RICHMOND AMERICAN HOMES JOB#28520046

PLOT PLAN LOT 23

Site Plan Drawing_V1.pdf Markup Summary

PLOT PLAN LOT 23

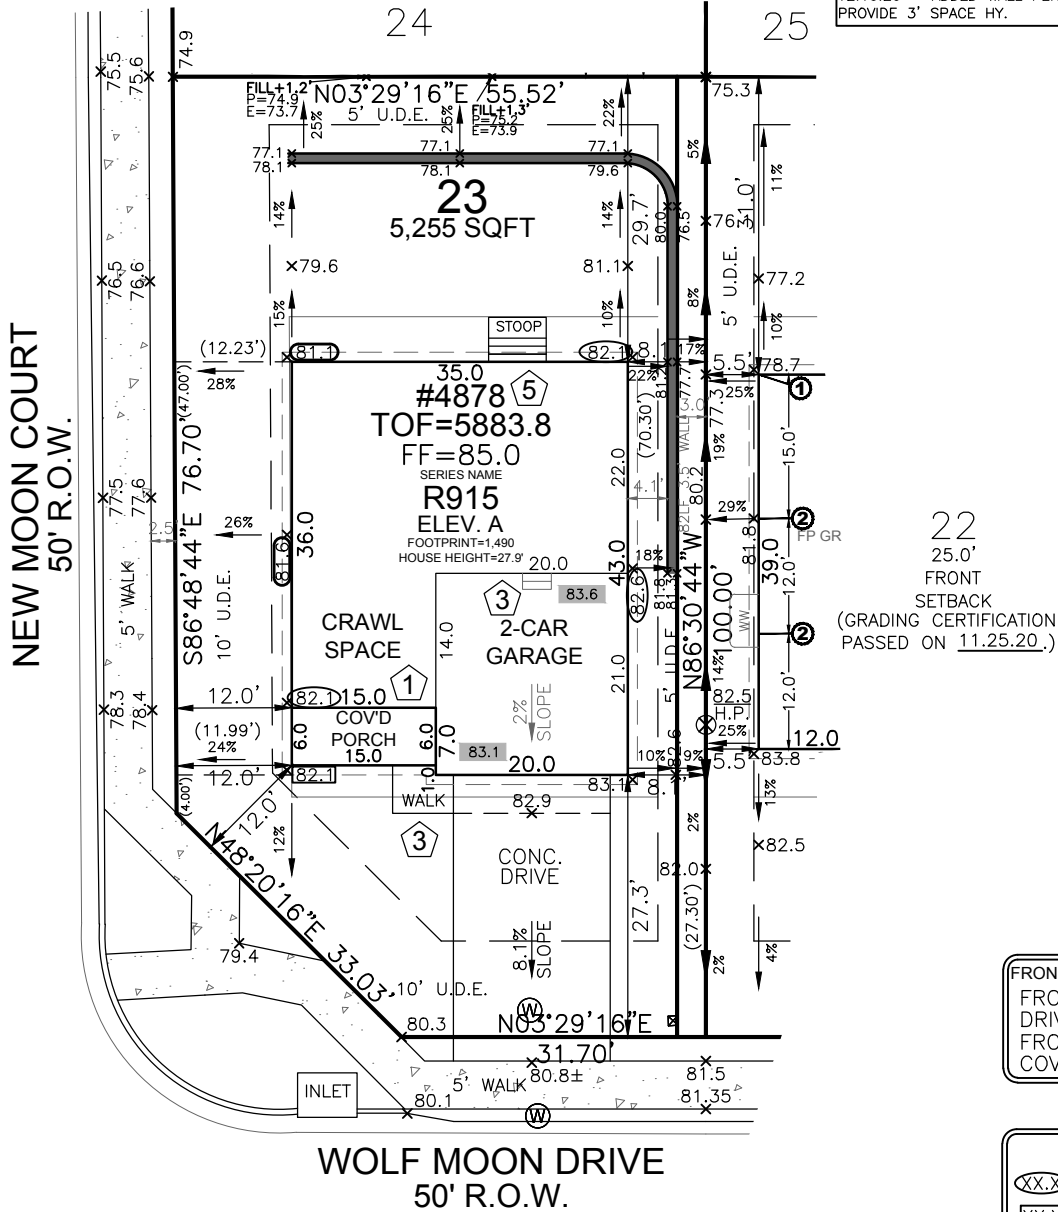
Proposed setback is not within **WOLF MOON DRIVE** 50' R.O.W. 20% of required setback of 15 feet to qualify for Admin. Relief. The required setback on the second front yard on a corner lot is 1/2 of the required front yard or 15 feet, whichever is greater. 15 feet is greater than 12.5 feet, or half of the front yard required. Therefore, the reduction can only be requested up to 12 feet (80% of the 15 feet required)

Proposed setback is not within 20% of required setback of 15 feet to qualify for Admin. Relief. The required setback on the second front yard on a corner lot is 1/2 of the required front yard or 15 feet, whichever is greater. 15 feet is greater than 12.5 feet, or half of the front yard required. Therefore, the reduction can only be requested up to 12 feet (80% of the 15 feet required)
